**KIRKLEES METROPOLITAN COUNCIL
INVESTMENT & REGENERATION SERVICE**

DELEGATED DECISION TO DETERMINE PLANNING APPLICATIONS

Reference No:	2020/62/91919/W
Site Address:	The Co Operative Food, 19, Northgate, Almondbury, Huddersfield, HD5 8RX
Description:	Demolition of existing supermarket and erection of block of 5 flats with associated parking (within a Conservation Area)
Recommending Officer:	Emma Thompson

DECISION – Full Conditional Permission

PROPOSED ELEVATIONS C & D

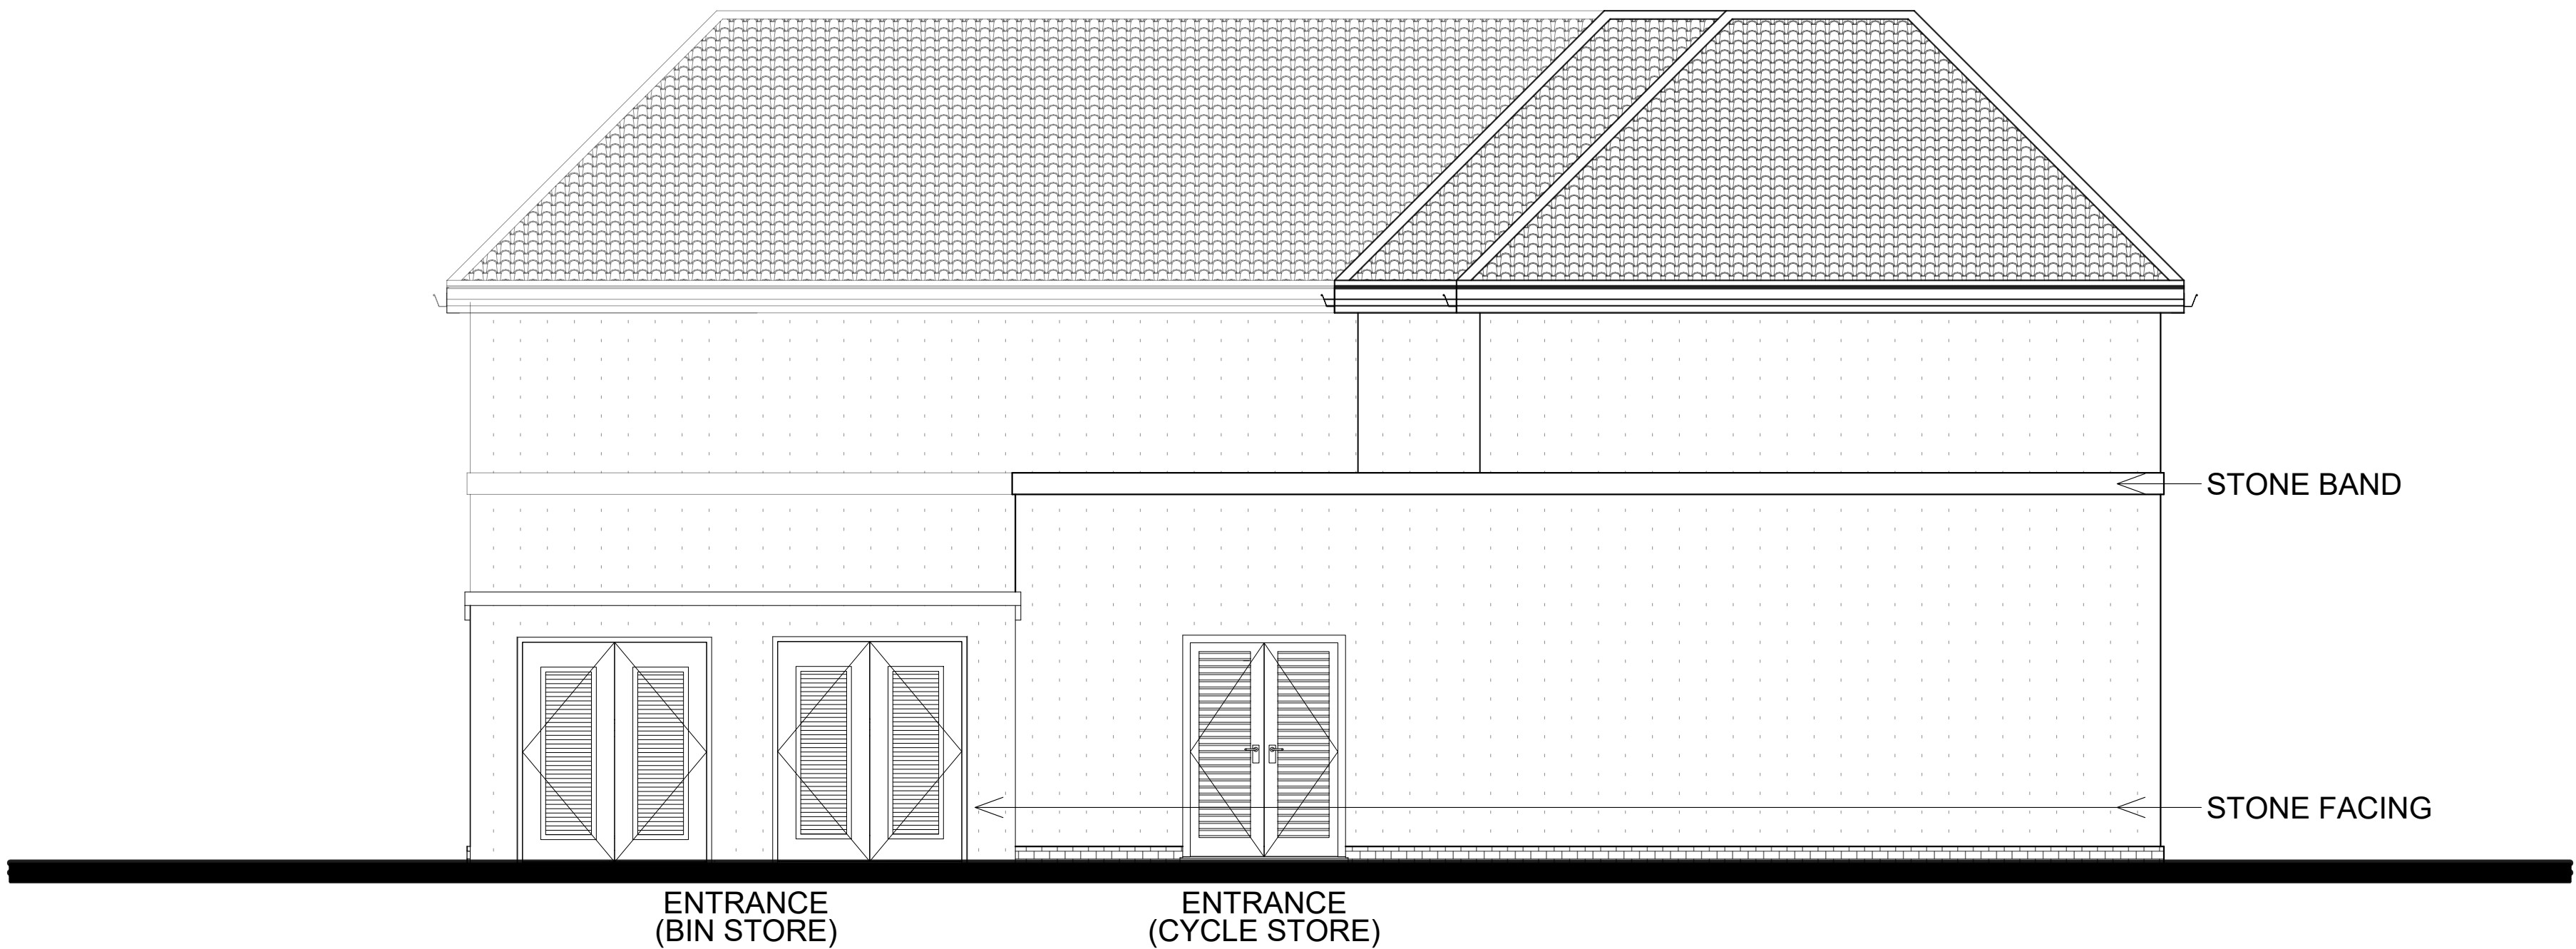
The proposed building has been amended to take into account concerns regarding the proximity to existing neighbouring properties. The building shows a relatively square footprint with L shaped first floor removing the massing from the nearest corner to Brickbank.

The roof to the main structure is pitched with the single storey element which is tucked at the rear of the site shown as flat. The elevations are traditionally designed with mullioned windows and stone detailing. The flat roofed element is designed to mitigate impact on nearby occupants and is not considered to appear detrimental to the character of the area due to its location at the rear and scale.

The revised plans show natural stone finish which is recommended to be secured by condition in the event that planning permission be approved, to ensure it enhances the Conservation Area. It is recommended that a fair faced natural stone or similar for the coursed external walling, with ashlar stone for the window surrounds and mullions with the addition of ashlar gutter corbels. The Conservation Officer has recommended that the new dwellings at 3 and 5 Westgate are used for reference. There are no roofing materials shown on the drawings, due to the location in the Conservation Area and opposite existing Listed Buildings it is considered stone slates should be used and samples submitted for approval prior to use.
